Re: Major Project MP08_0244 Environmental Assessment (EA) for Construction of a Mixed Use Commercial, Retail and Residential Development at 23-37 Lindfield Avenue and 11 Havilah Avenue, Lindfield

I am writing to express **key objections** regarding the above EA.

A	DA	20	B
disc	stage	dwg no	revision

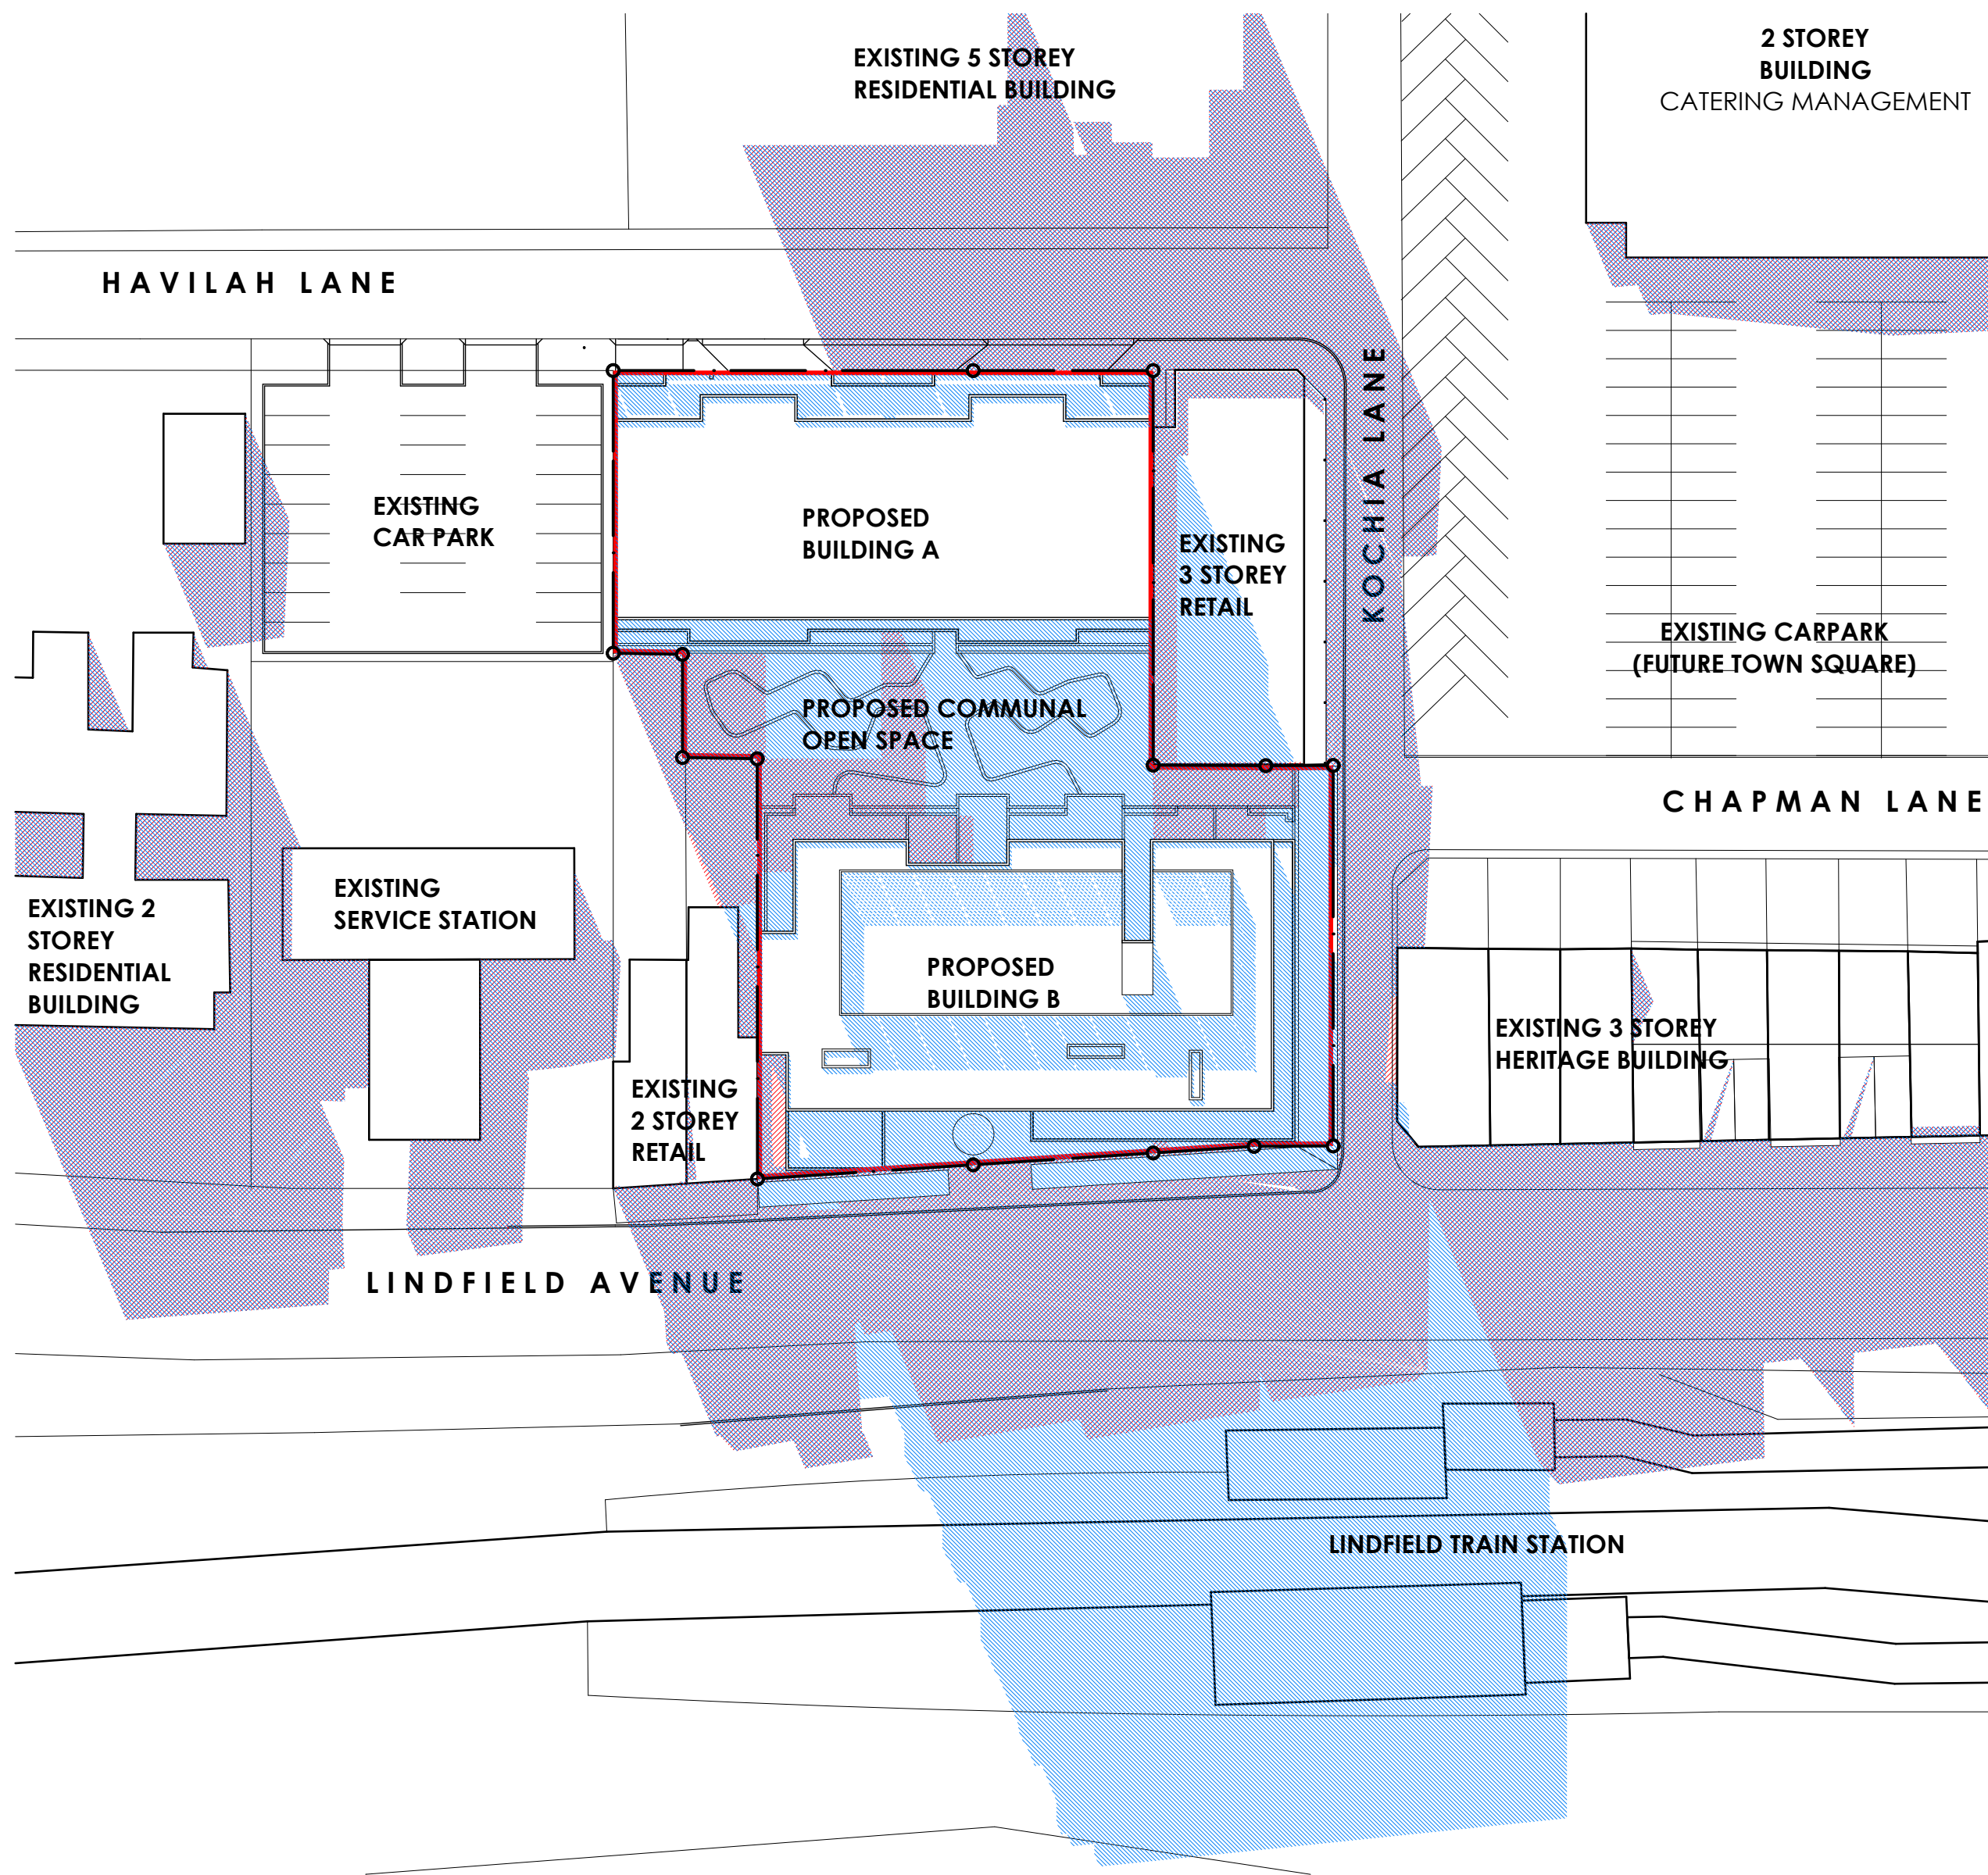
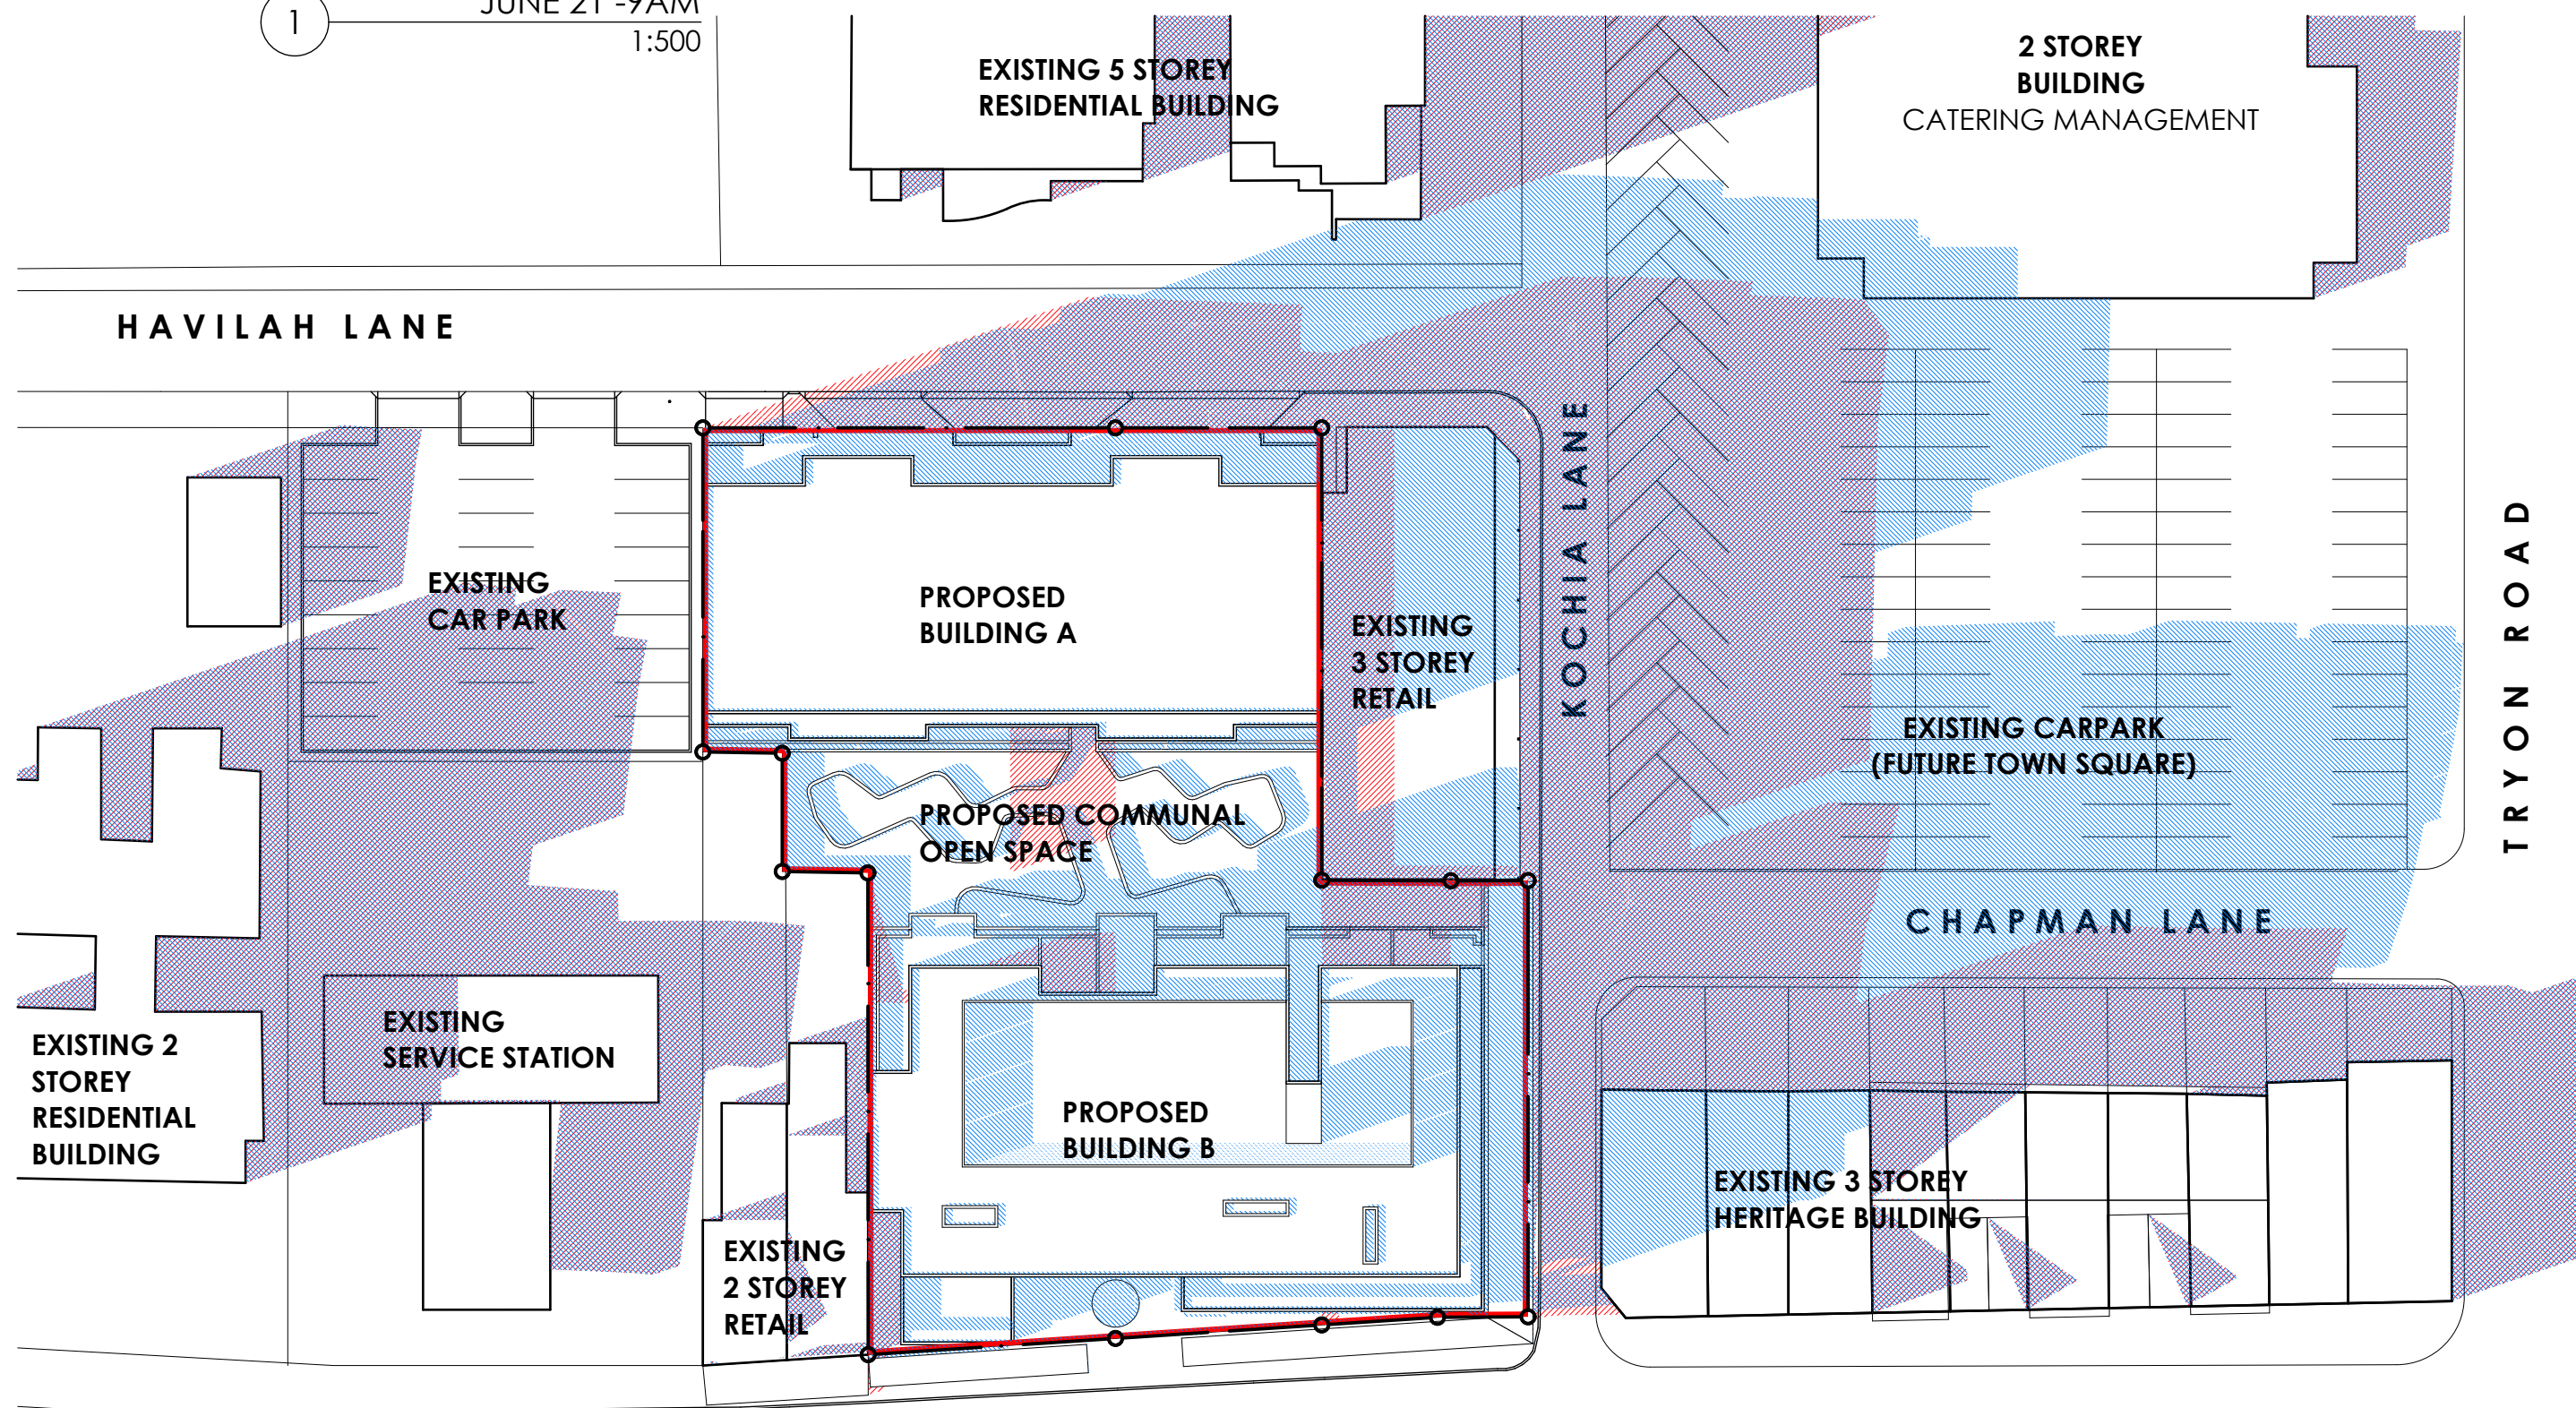
- The Lindfield Avenue building at 7 storeys will cast **significant shadow on the railway station (which is an open station)**, affecting a larger number of commuters as per the March, June and September Shadow Diagrams.

- **The development will cast significant shadows on future open space in the proposed town centre, causing loss of amenity to the broader community**, as per the June and September Shadow Diagrams.

b) Maintain development to a maximum of 5 storeys, in line with the broader Lindfield environment.
